From:
Sent: 13 October 2024 19:43
To: DC Admin
Subject: FW: 168 Scholes Lane, Scholes, Cleckheaton BD19 6LX - Application number 2024/92316

I am writing regarding the above application number as the owner of 138 Scholes Lane, Scholes, Cleckheaton BD19 6LX as, if passed, the proposed residential development could impact my property so I would like to raise a concern that I have:

SITE PLAN 1:500

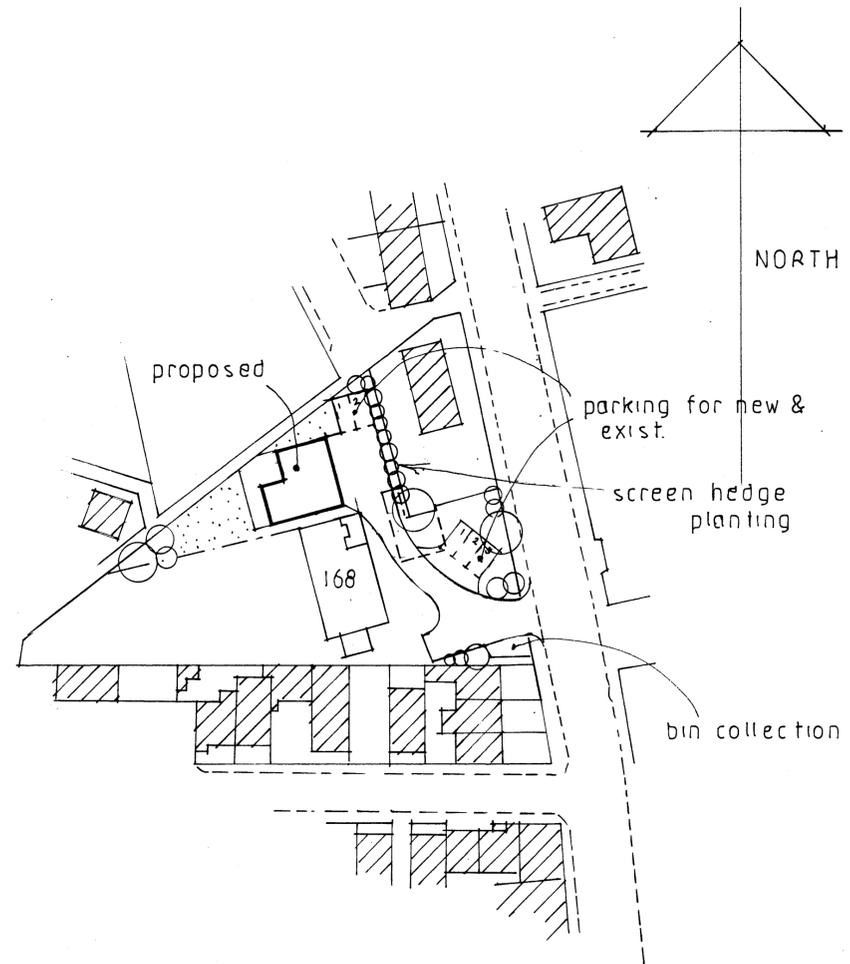
The main sewer runs on land that it owned by me and, therefore, permission would be required to connect as it would involve excavation on my land if the intention is to connect at that point.

Part of my property is located directly behind the gable end of the proposed dwelling. I have planning permission to erect solar panels on the flat roof along with an environmentally friendly live green roof. This was passed in November 2022 and the planning reference is 2022/62/91964/E. I also have a nature friendly mature hedge which runs along my boundary, and which is directly next to part of the Kirklees Way. I am very concerned that the gable end to the proposed dwelling will impact my plans for the solar panels and live green roof along with the mature nature friendly hedge by cutting sunlight from my south facing property. I would, therefore, like to know what the proposed height of the gable end is so that I can understand any potential impact on light and, therefore, on nature within a conservation area.

For the same reason, I would like to know whether there will be any restrictions, if the application is successful, on the height of the boundary wall which is currently a low traditional dry-stone wall with a low wire fence above it.
